Application reference number	2025/0448
-------------------------------------	-----------

Proposal Description:	Regrade of pavement levels to provide level threshold and create accessible entrance to the bank's existing entrance
Location:	26 Market Hill, Barnsley, S70 2QE

Project
Level Access Program
 Title
Barnsley External Regrade Scheme
 Client
NatWest Group
 Purpose :
 Scale @ A1:
As indicated

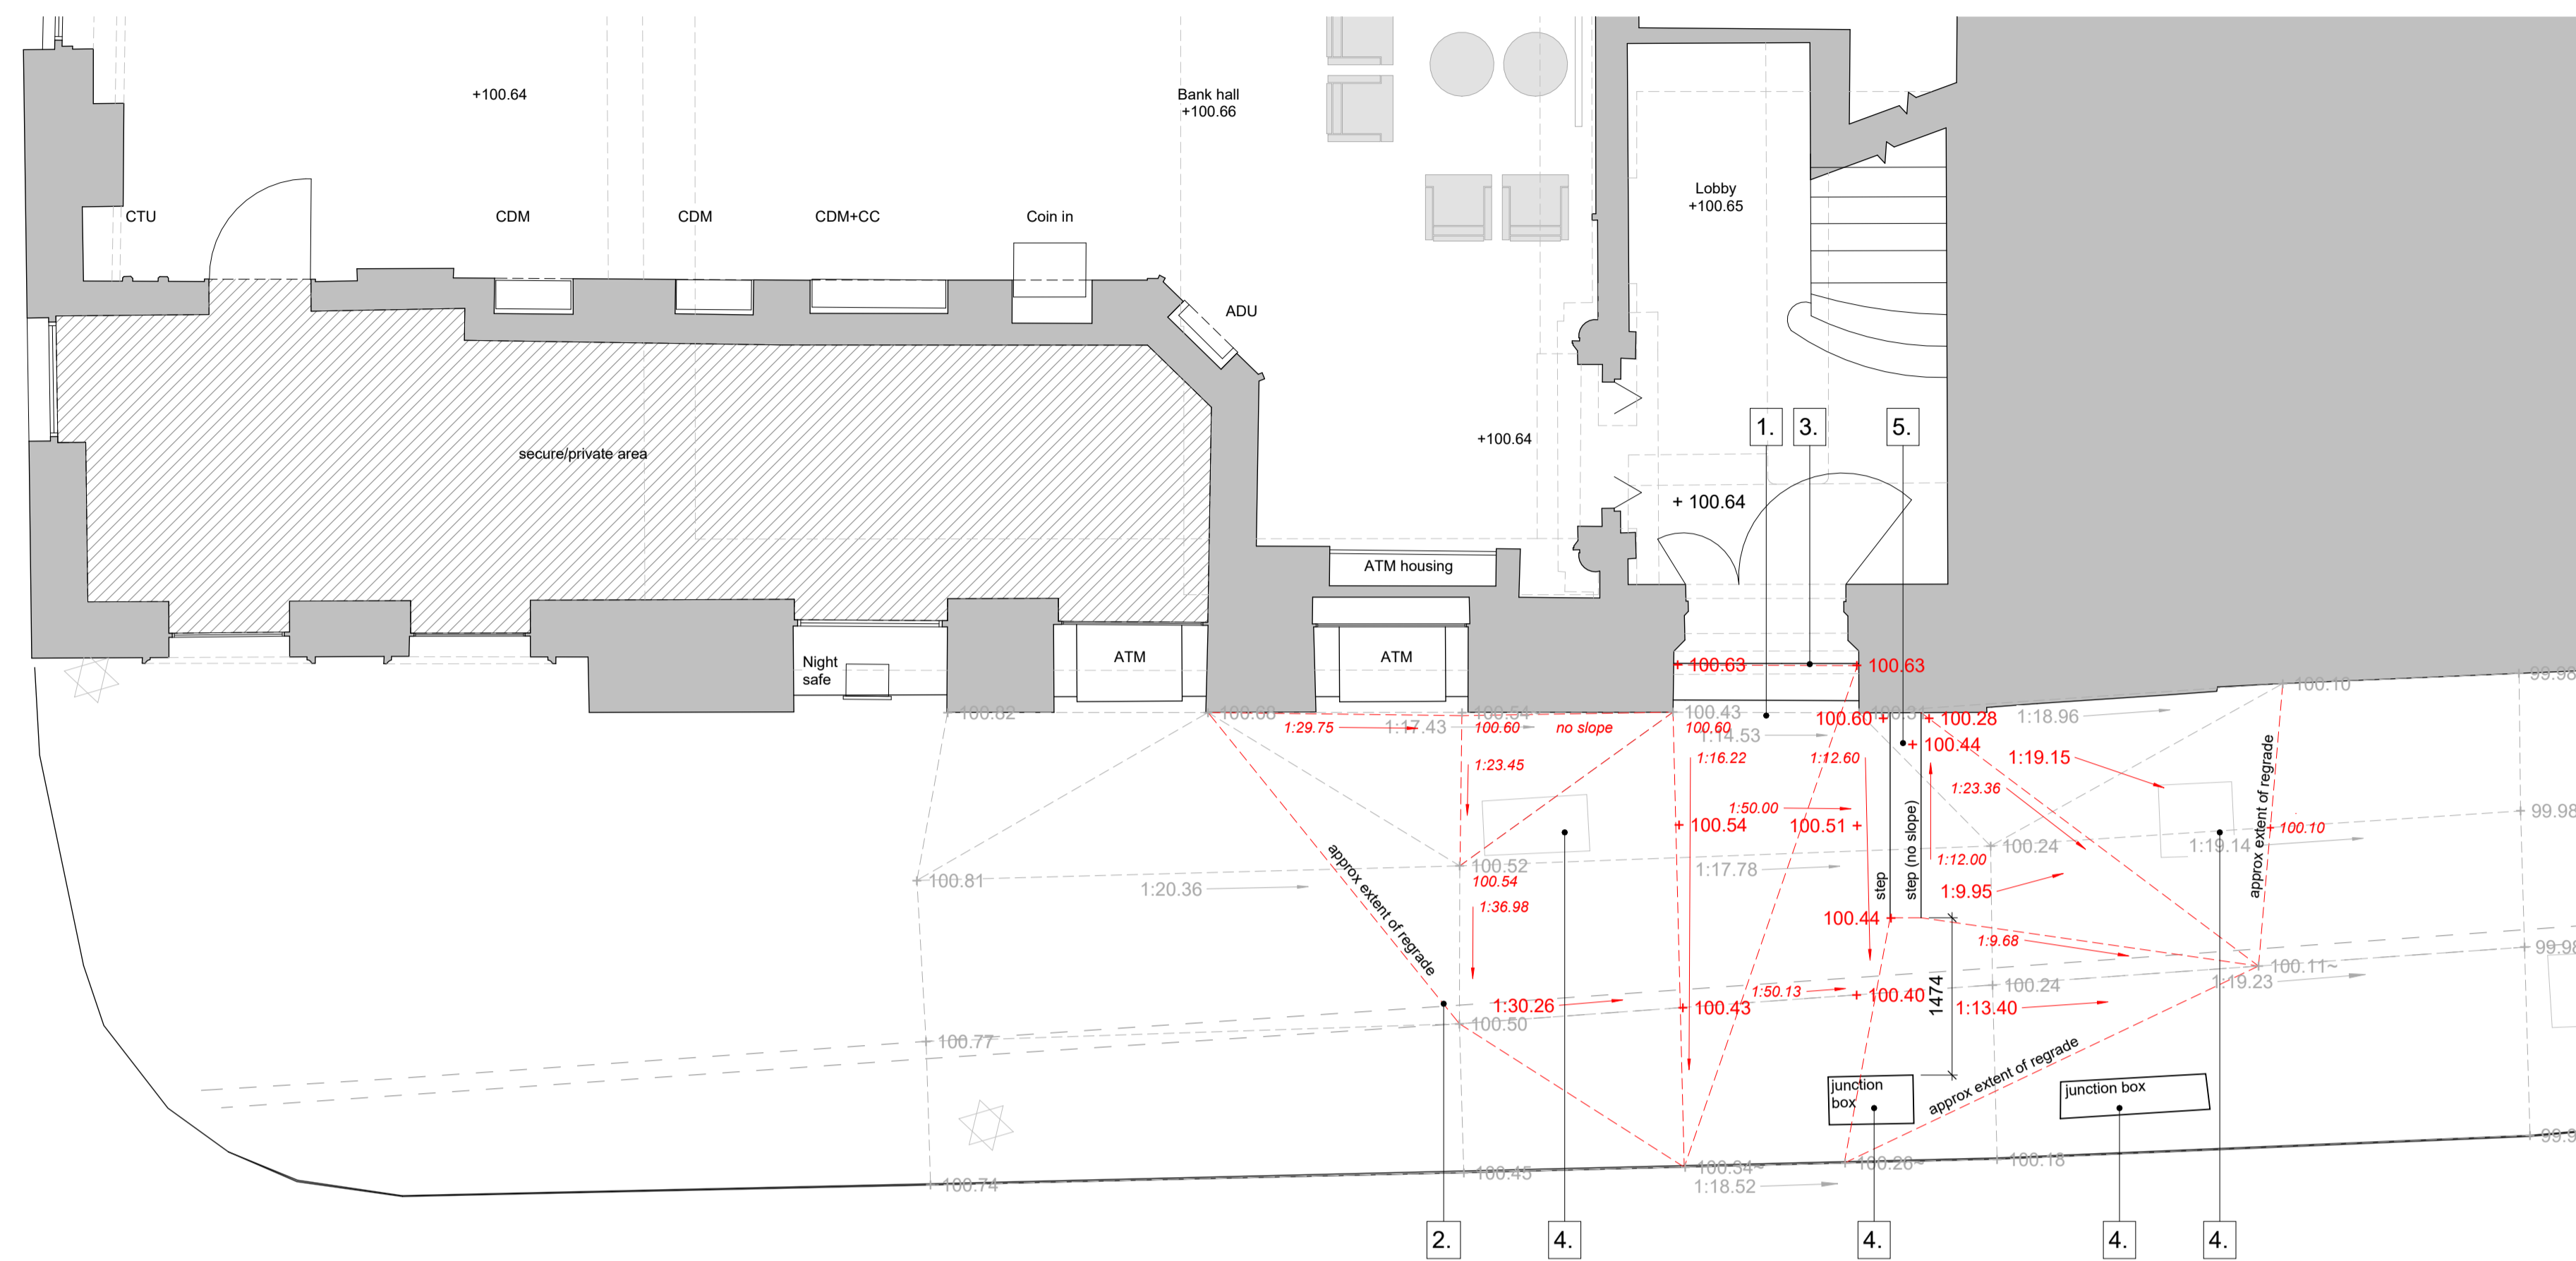
The applicant initially sought permission to regrade the footpath with the inclusion of steps within the public highway; following comments from Highways Development Control, amendments were sought as it was considered that the initial design would be unsafe due to there being no handrail or barrier between the proposed steps and the path. The proposal was considered disadvantageous to the Council as it introduced a significant trip hazard and narrowed the un-stepped path to less than 2.0m, which would create issues, in particular for disabled and visually impaired highway users.

Whilst the amended plans removed the stepped section and incorporated a longer length of pavement regrading, the plans incorporate elements that exceed the recommended maximum gradient of 1:12, with a preferred being 1:20.

Section B.1.1.28 of the South Yorkshire Residential Design Guide (SYRDG) states that whilst it is preferable to have a level approach, where the topography prevents this, a maximum gradient of 1:12 is permissible on an individual slopes of less than 5 metres or 1:15 if it is between 5 and 10 metres, and 1:20 where it is more than 10 metres. Whilst overall the length is over 10m there are sections of the regrading which exceed the maximum gradient of 1:12. As such, this weighs considerably against the scheme which would remain unacceptable from a highways perspective and contrary to Local Plan Policy T4 New Development and Transport Safety.

In the opinion of the Local Planning Authority, the proposed regrading of the pavement, by reason of its inappropriate, varied grading ratios within the adopted highway would fail to provide all users within and surrounding the development with safe, secure and convenient access and movement contrary to Local Plan Policy T4 New Development and Transport Safety.
